**From:** Estelle Meagher [REDACTED]  
**Sent:** 13 May 2021 16:32  
**To:** Finlay Gardner <[Finlay.Gardner@arun.gov.uk](mailto:Finlay.Gardner@arun.gov.uk)>; Planning <[Planning@arun.gov.uk](mailto:Planning@arun.gov.uk)>  
**Subject:** Objection to Planning Application BR/93/21/PL 22 Neville Road Bognor Regis

We object to the erection of a single story dwelling in the garden of 22 Neville Road - Planning Application BR/91/21/PL. The house which the application refers to is already a split development, with a shared drive to the neighbouring 24 Neville Road. The application is in conflict with the parking allocations stipulated by West Sussex County Council for new developments, with inadequate provision.

Component: **Proposed Ground Floor Plan**

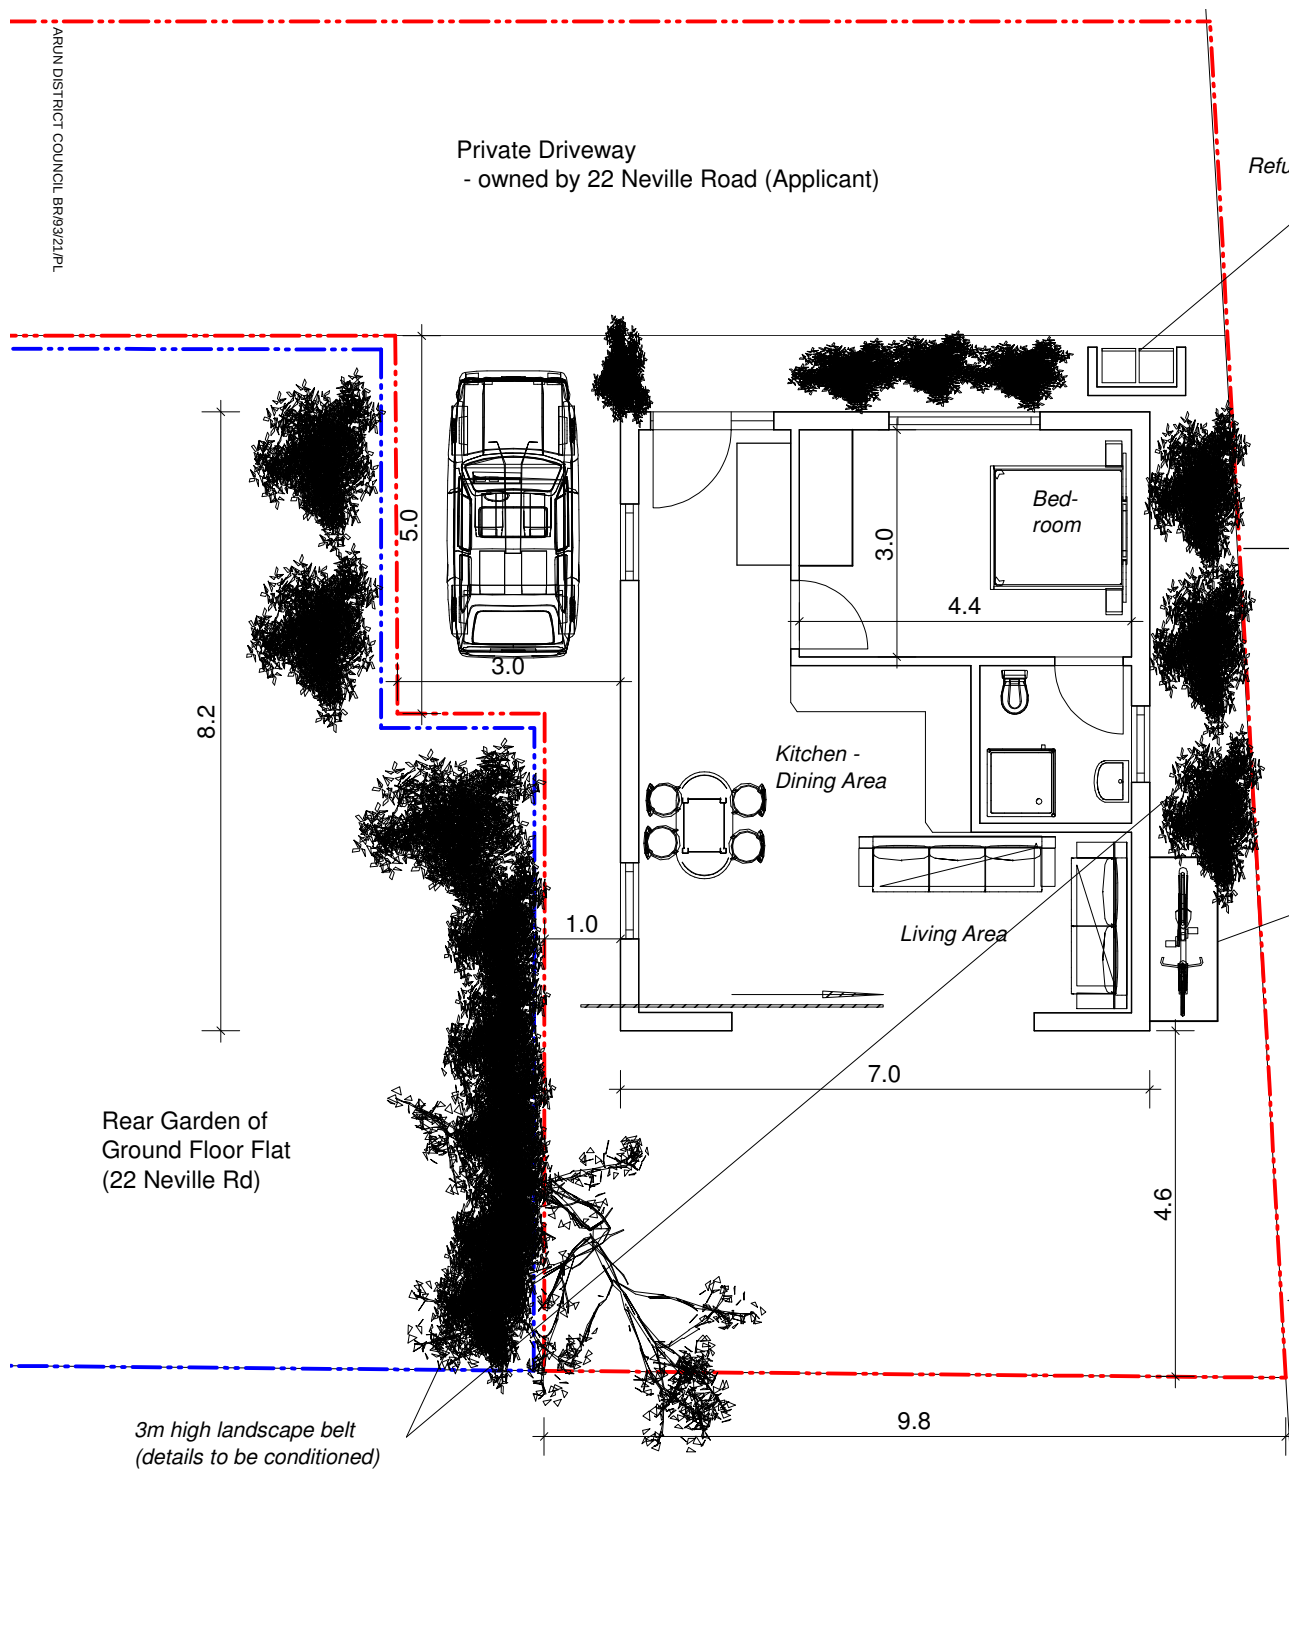
The position of the site and size is such that the development would result in a cramped and overlooked structure that is not in keeping with the layout of residencies within the local area. The dwelling is very close to its boundaries to make it 'fit in' to the space proposed which is an area of garden separated from the split development off 22 Neville Road used by its occupants.

The proposed site and this application would result in an inadequate living environment for prospective occupants, The dwelling would be hemmed in on all sides, and overlooked by existing residents on all sides. Vehicles using the shared drive would be in conflict, the over intensification of the drive would result in noise irritancy and nuisance to neighbouring residents.

a contrived and speculative use of garden land, but fails to provide adequate living conditions for prospective occupants, falling short in design, appearance, positively responding to local character, and providing future occupants with a cramped overlooked accommodation, which fails the 25% rule making the development feel oppressive to any potential residents. And result in overdeveloped unneighbourly and overbearing impact on existing residents and conflict of use, of shared driveway and public footpath adjacent to the property.
